Our Ref: 2669/PJ/FD/140111

14 January 2011

Re: Submission – Oberon White Granite Quarry Environmental Assessment

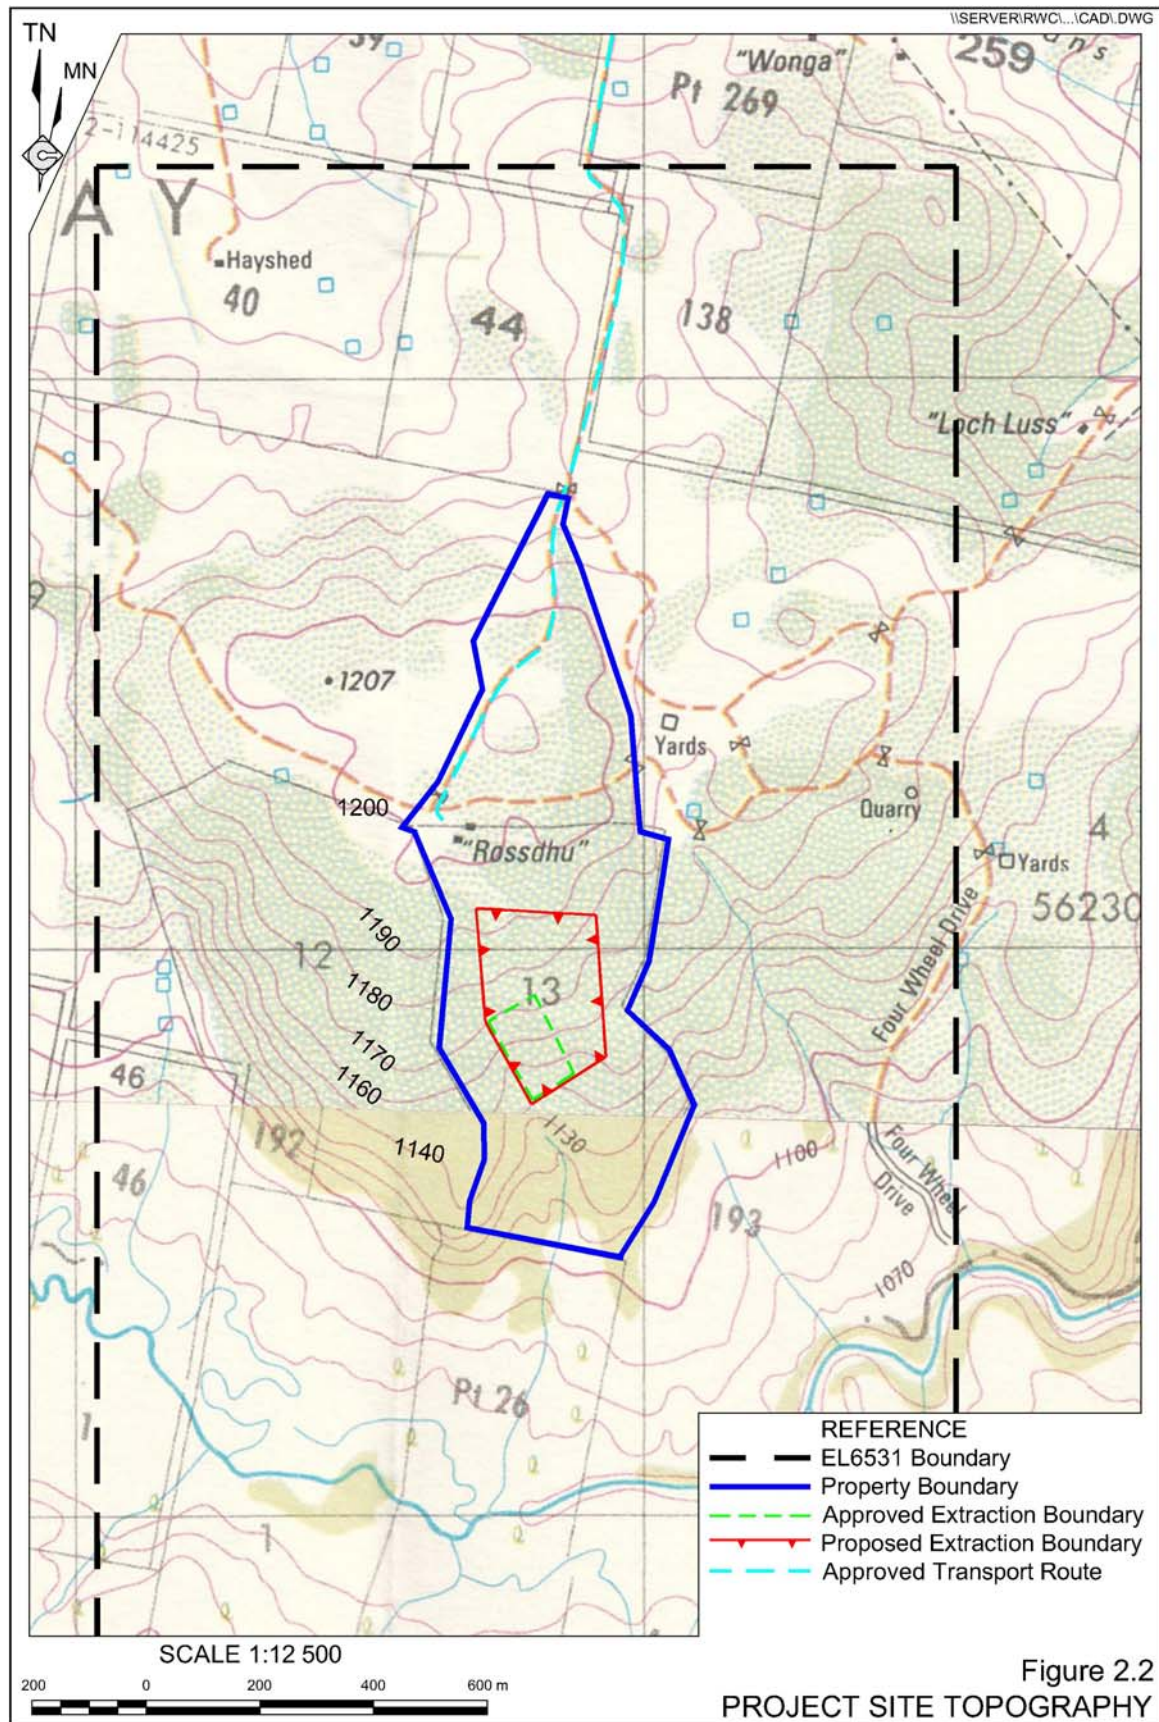
The topographic information used in undertaking the noise assessment that was prepared by Spectrum Acoustics for the proposed extension of Oberon White Granite Quarry was based on the LPMA 1:25,000 topographic series. As shown on attached **Figures 1** and **2**, there are errors with the 1:25,000 topographic series information at this location and consequently the noise model used does not accurately reflect the real topography and does not reflect a significant noise attenuating ridge that exists between Webb's proposed dwelling site on Lot 12 and Oberon White Granite Quarry.

Hugh & Sue Webb engaged qualified surveyors Tablelands & Buttsworth to survey the intervening landform in early 2010. As shown on **Figure 2**, the actual landform between the quarry and the dwelling location is up to 25 metres higher than depicted on the 1:25000 topographic series sheet that was used in the noise modelling. As a result, the intervening terrain between the quarry and the dwelling location provides significantly greater noise attenuation than the 1:25000 topographic series landform that was used by Spectrum Acoustics for the Oberon White Granite Quarry Environmental Assessment.
